Sent: 05 October 2013 10:54
To: Planning
Subject: Welwyn Hatfield Council Online Planning - Comment

Application Number: N6/2013/1938/MA

Comment Type: Object

Title Proposed Materials

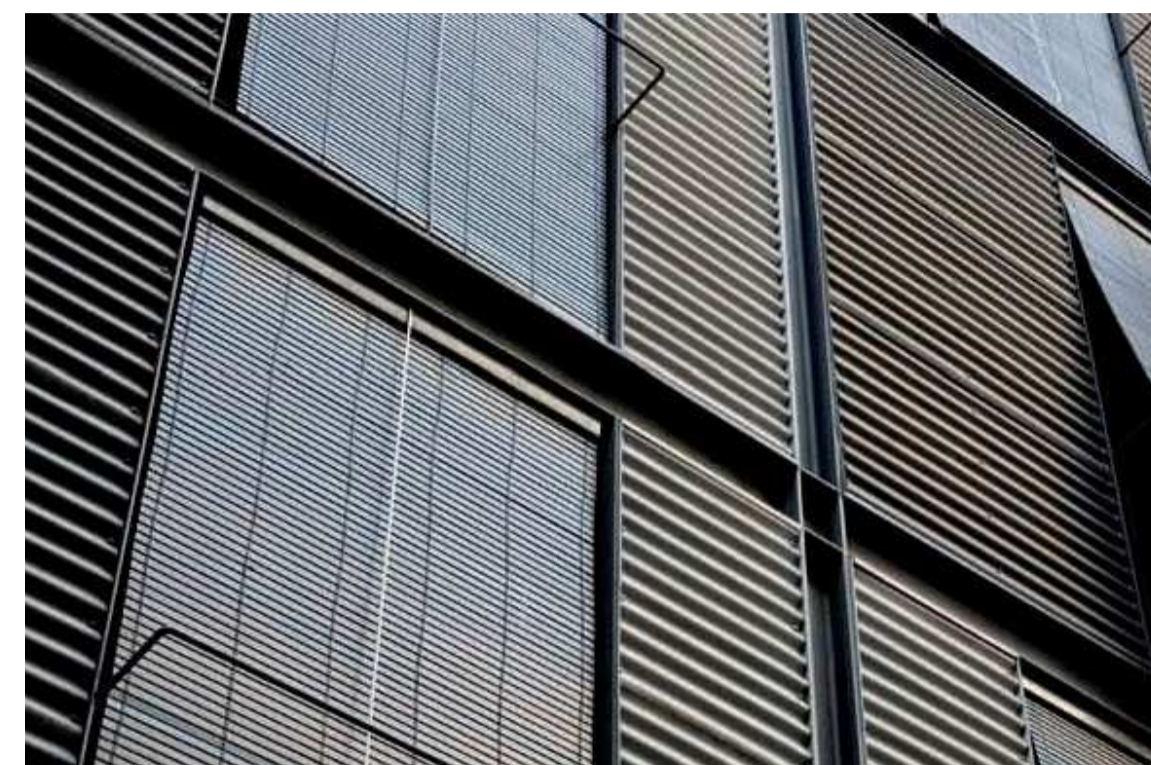
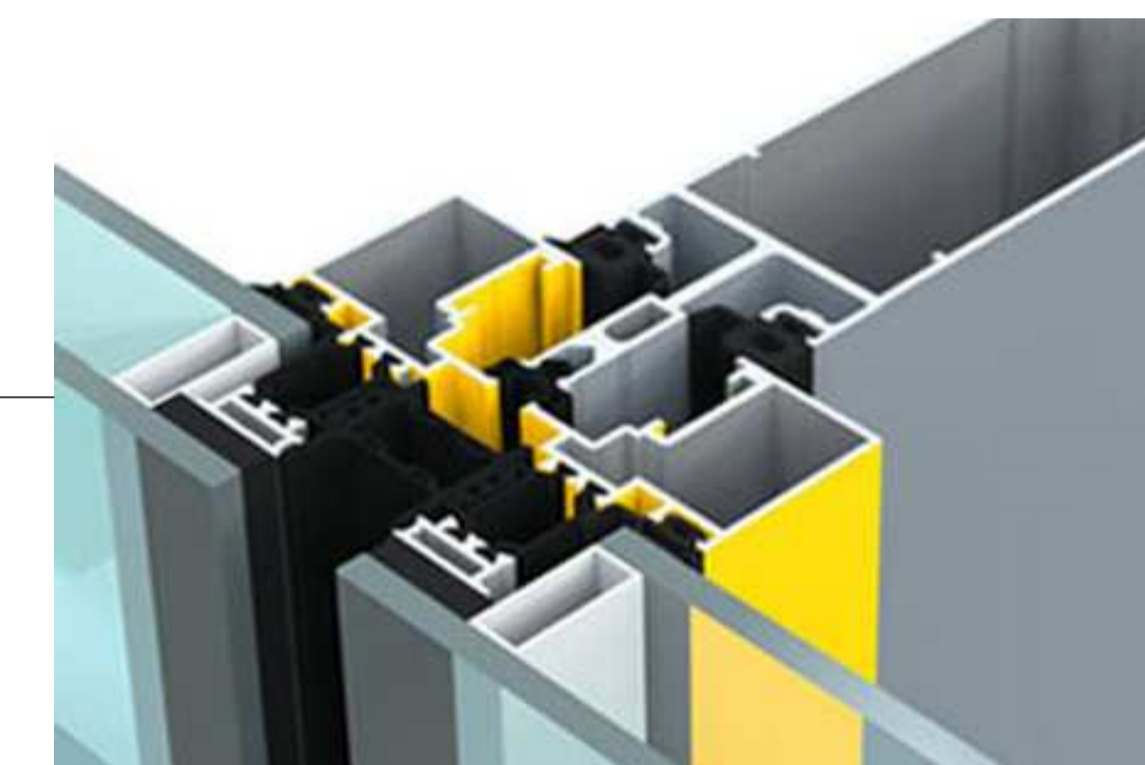
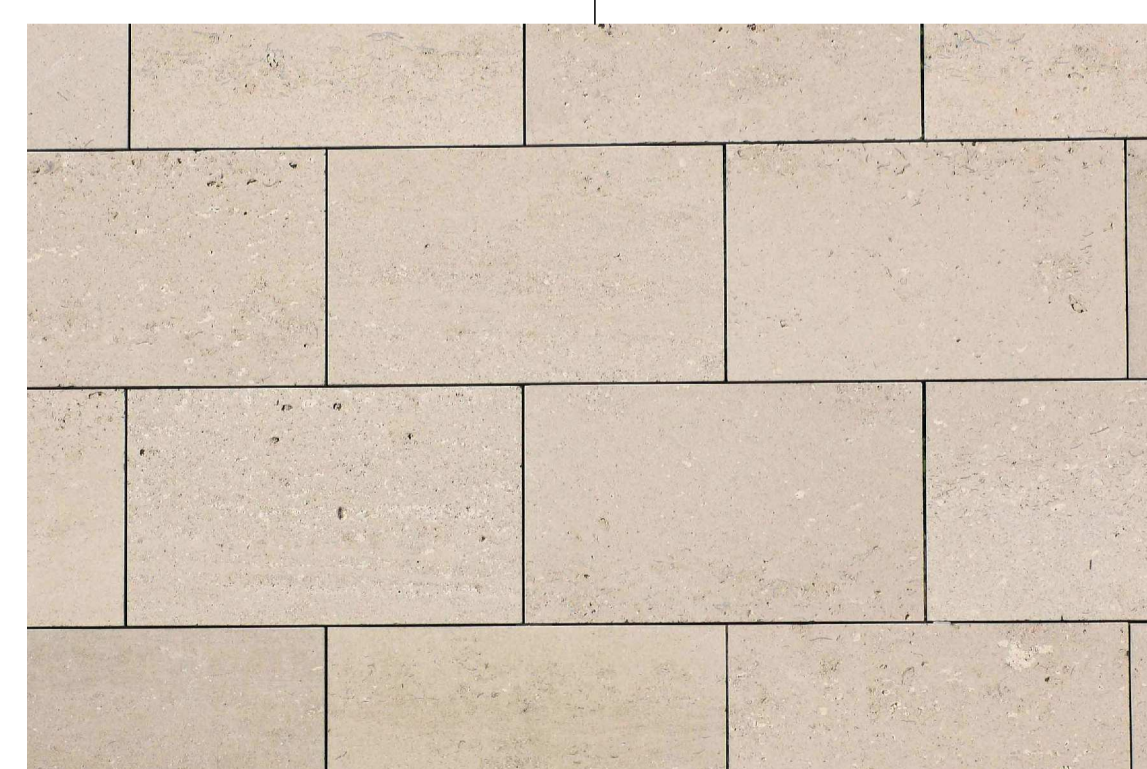
Comment: As this proposal is in a Conservation Area, the materials of the entrance facade are inappropriate. They do not, in any way, fit in with the existing building.

The external view could be in almost any 'new build' location and have nothing of the character of the essence of WGC.
